**Consultation Response from KC,
Highways Development Management****2026/90314 Land adj, 108, South Parade, Cleckheaton, BD19 3AF****Erection of two dwellings and associated works****Date Responded: 18/03/2026****Responding Officer: D. Stainsby****Responding Ref: K9-3SW/38**

This application is for the erection of 2 dwellings.

Proposed Front Elevation

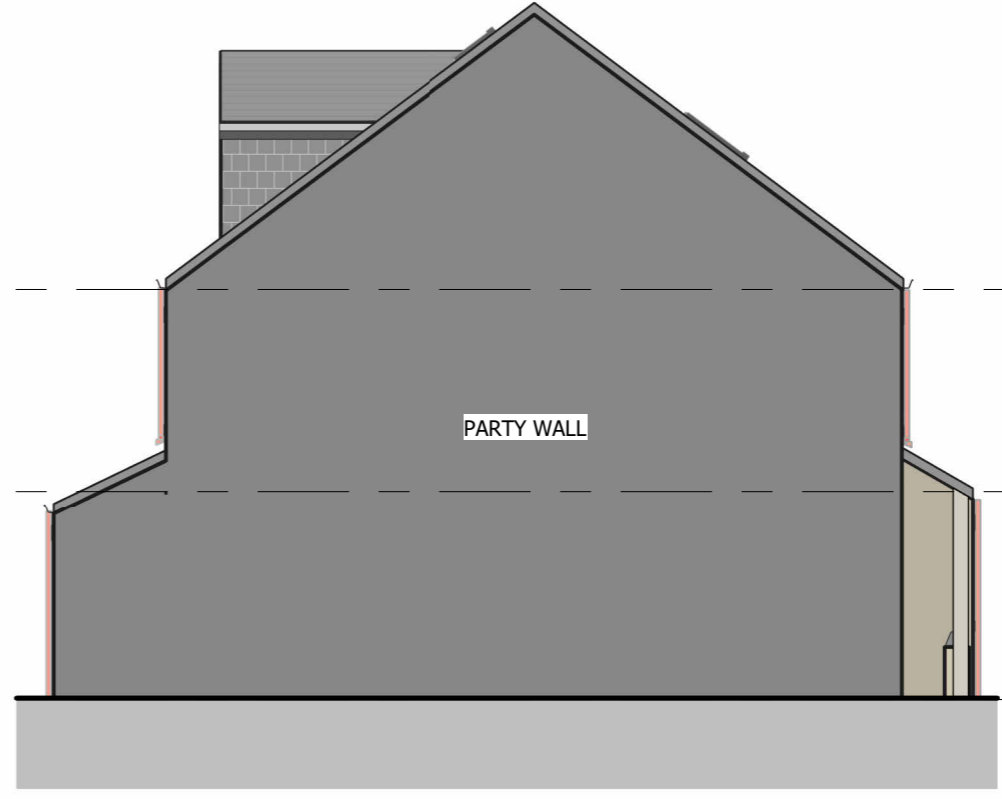
An access to both proposed dwellings is shown on to South Parade. However, a new vehicular crossing will need to be provided for the proposed access.

A telegraph pole is located on the site frontage. To achieve an acceptable access to the site, this may require relocating.

No bin store and/or bin collection/presentation is shown on the proposed plans.

A bin collection/presentation point should be located adjacent to the public highway and must not obstruct the adopted highway or the parking spaces.

Details of the waste collection for the proposed dwelling should be provided, with the location of a waste collection presentation point being clearly marked on a drawing in such a location that is easily accessible to the collection team and where it will not obstruct the access or the adopted highway for road safety reasons.
